Arun District Council
Arun Civic Centre
Maltravers Road
Littlehampton
West Sussex BN17 5LF
Planning & Building Control General Enquiries
Tel: (01903) 737756 Fax: (01903) 730442
Dx: 57406 Littlehampton
Minicom: 01903 732765
e-mail: planning@arun.gov.uk
website: www.arun.gov.uk/planning

Application No: P/122/25/HH
Site Address: 22 The Green Pagham PO21 4SB
Description of works: Balcony over existing conservatory.

Thank you for your internet representation made on 21st December 2025 which has been recorded as an objection with the comments as follows:

ELEVATION AS PROPOSED
2A4 1:100

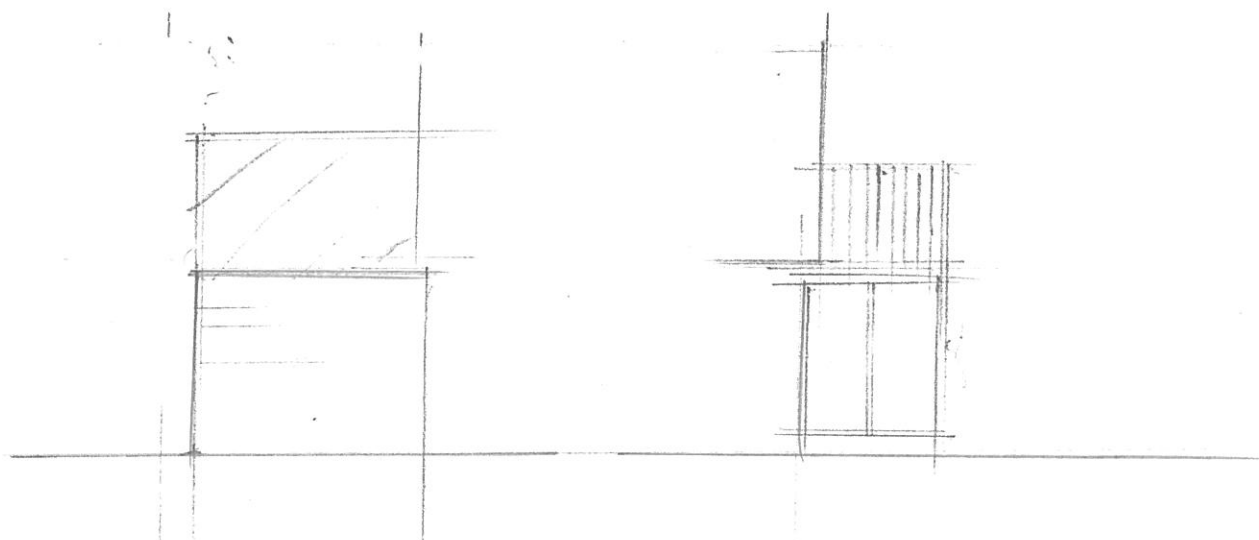
Concerns over losing exiting privacy as balcony will overlook our back garden. Plan shows 1.8m high obscured glass to south elevation but not to north which is directly overlooking our back garden.
